DRB CASE ACTION LOG (PREL/FINAL)

DRB Application No.: 08DRB-70066

Project Name: CIRCLE K CORPORATION

**CITY OF ALBUQUERQUE
PLANNING DEPARTMENT
February 20, 2008
DRB Comments**

**Plat of  
Tract A-1 and B-1  
Land of Circle K Corporation**

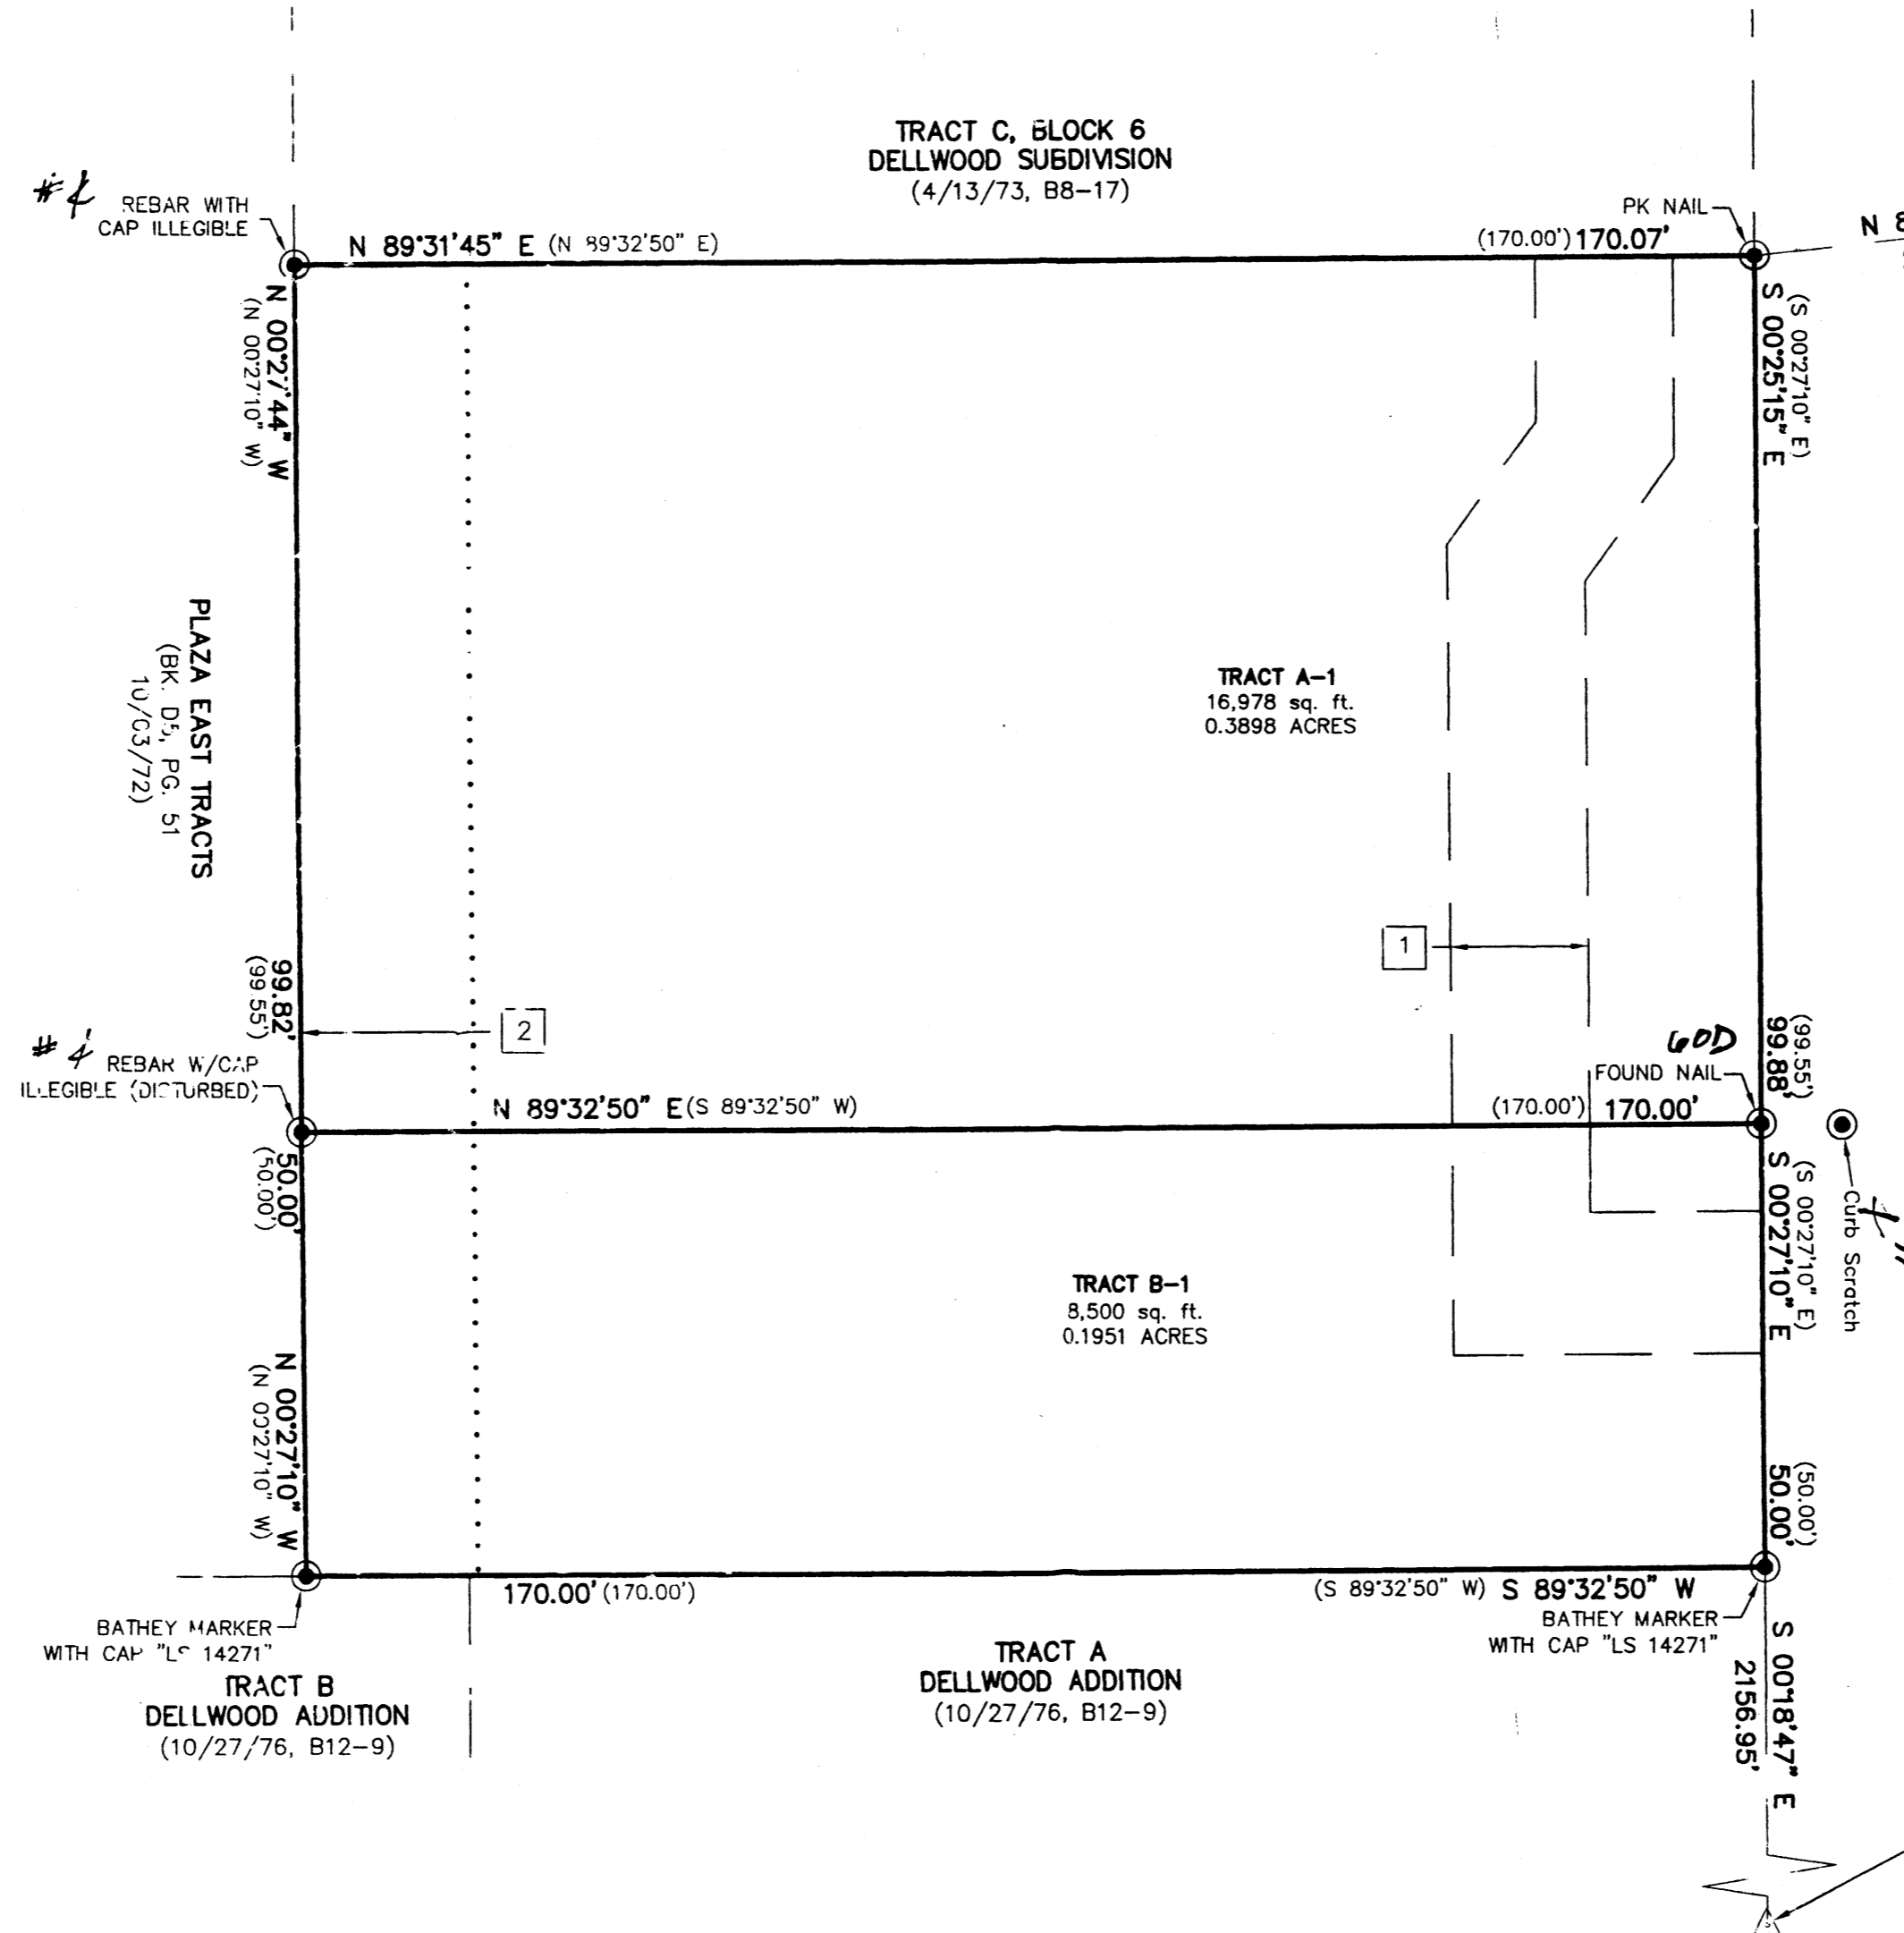
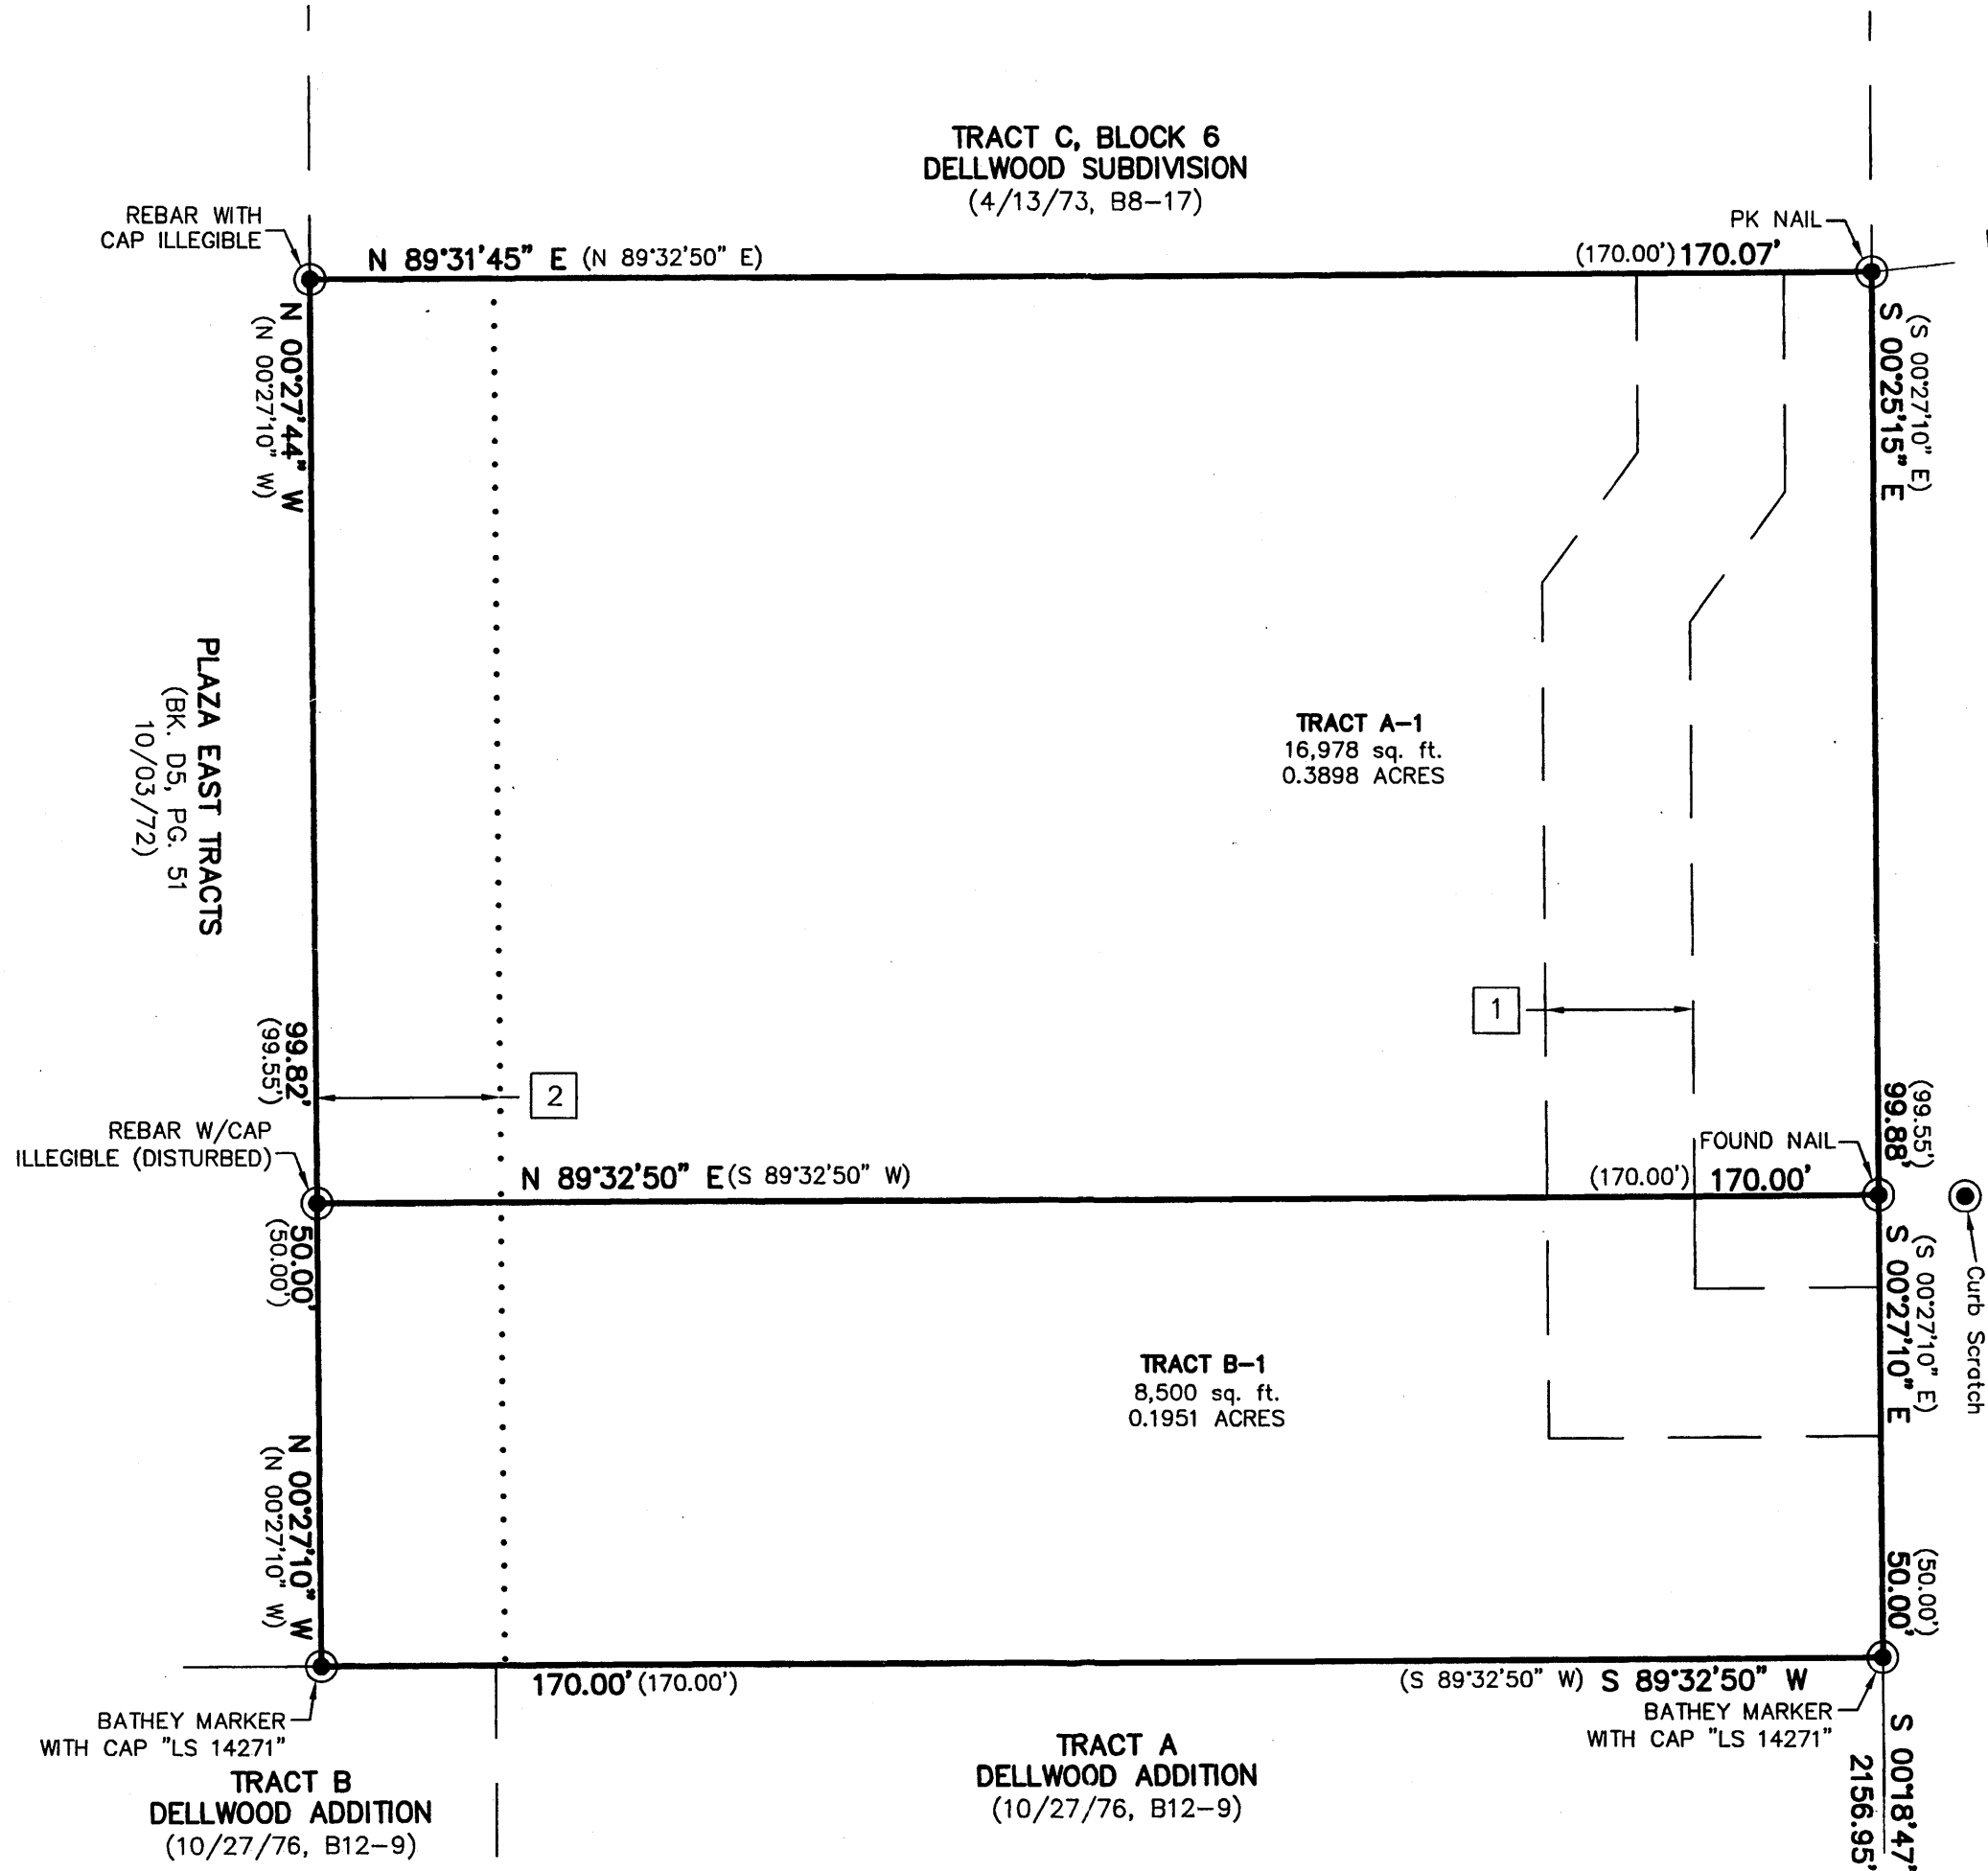
Please provide solar note per the Subdivision Ordinance [14-14-4-7] which is specific to this type of request, i.e. replace the words "REQUESTED FINAL ACTION" with the word "THIS PLAT" at the beginning of the note, and delete the words "OR SITE DEVELOPMENT PLAN FOR SUBDIVISION" at the end of the note.

The Planning Department will need to record this plat to complete the vacation action.
